DOC18/615865-03; EF13/3223

**Proposed Modification to Liddell Coal Mine, Modification 7 (DA 231-07-2000)
Exhibition Notice - Comments from the Environment Protection Authority (EPA)**

The EPA has reviewed *Environmental Assessment Modification 7 to DA 305-11-01* dated August 2018 (EA), and understands that the modification is seeking to make minor adjustment to the consent boundary to facilitate rehabilitation works in the historic Mountain Block mining area; clear approximately 1 hectare of remnant vegetation within the Mountain Block offset area; and make some minor administrative changes.

Figure 1: MBOA and receptor locations

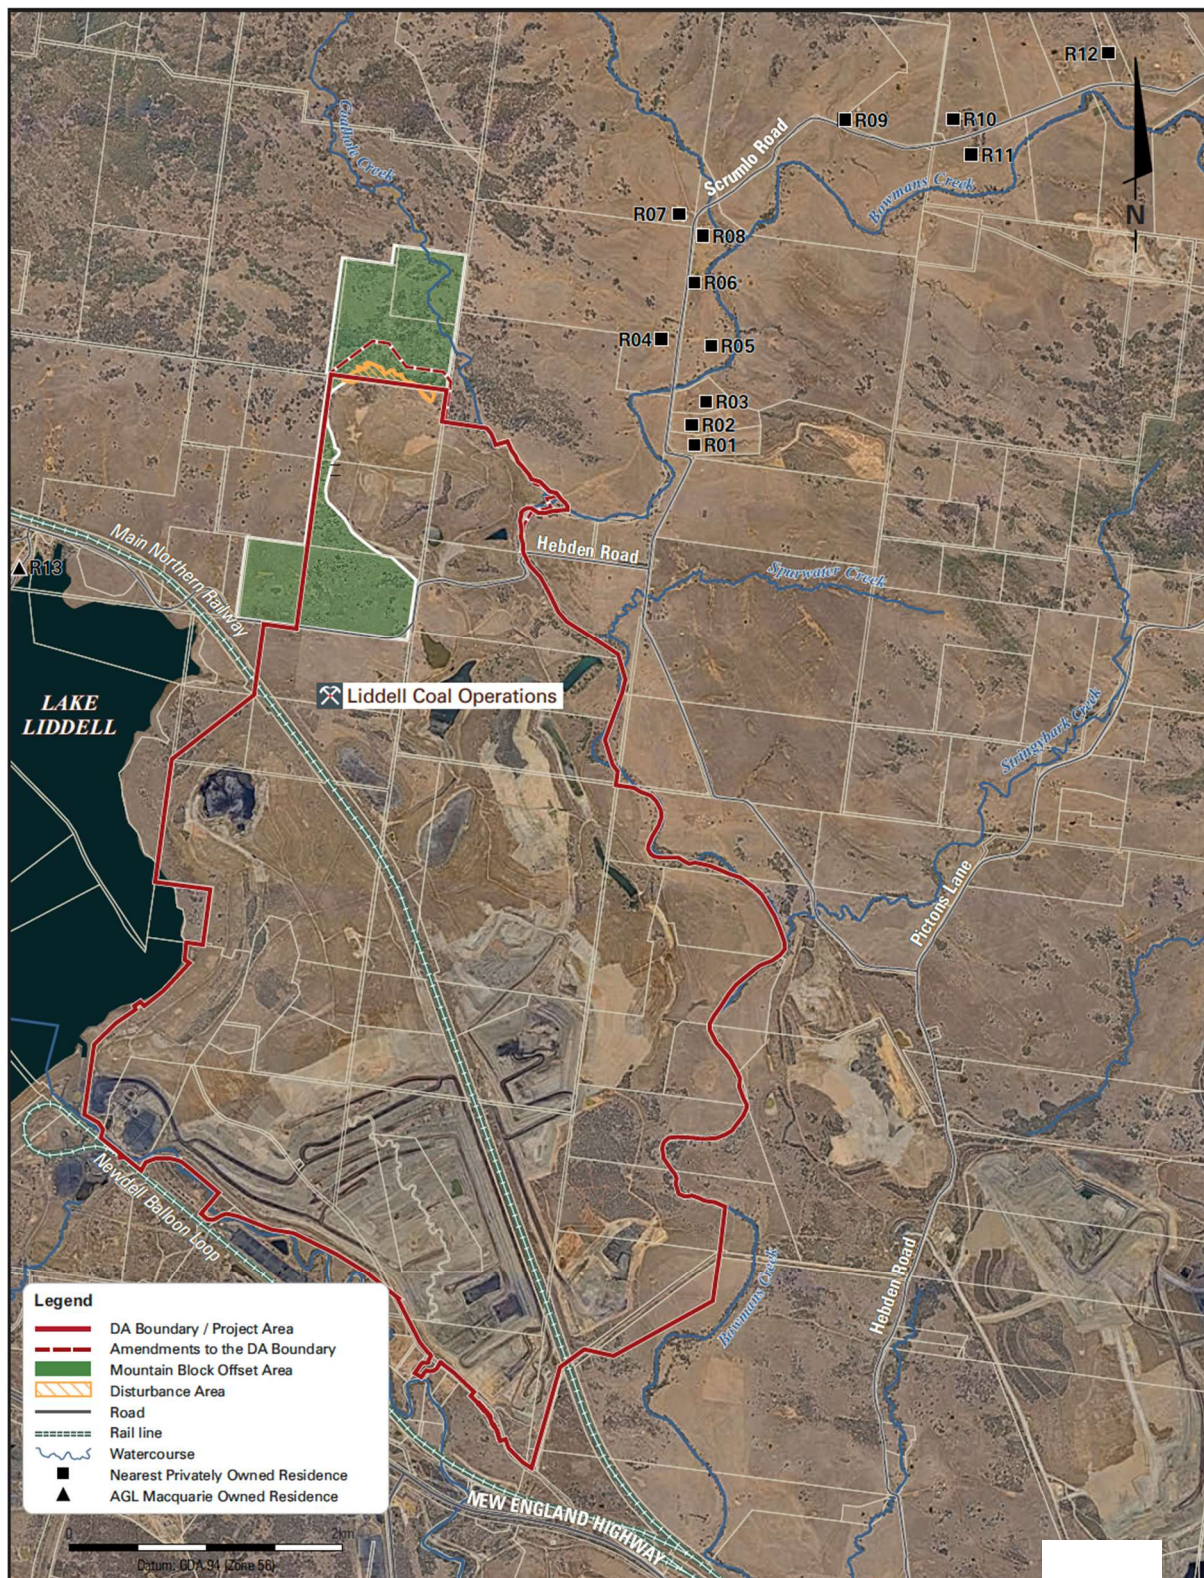
The EPA requires the proponent to provide an updated acoustic report that suitably calculates and models the likely noise impacts to residential receivers.

The Acoustic Report prepared by Global Acoustics at Appendix F of the EA states '*it is unlikely to be any increase in impacts to the community*'; however, this appears to be based on assumptions and not modelling despite the proposed activities being closer to receivers. While the EPA acknowledges that the proposed modification is relatively minor in the context of the operations undertaken at the Liddell Coal Mine in totality, the EPA requires a suitable assessment to fully assess the noise impacts from the proposal.
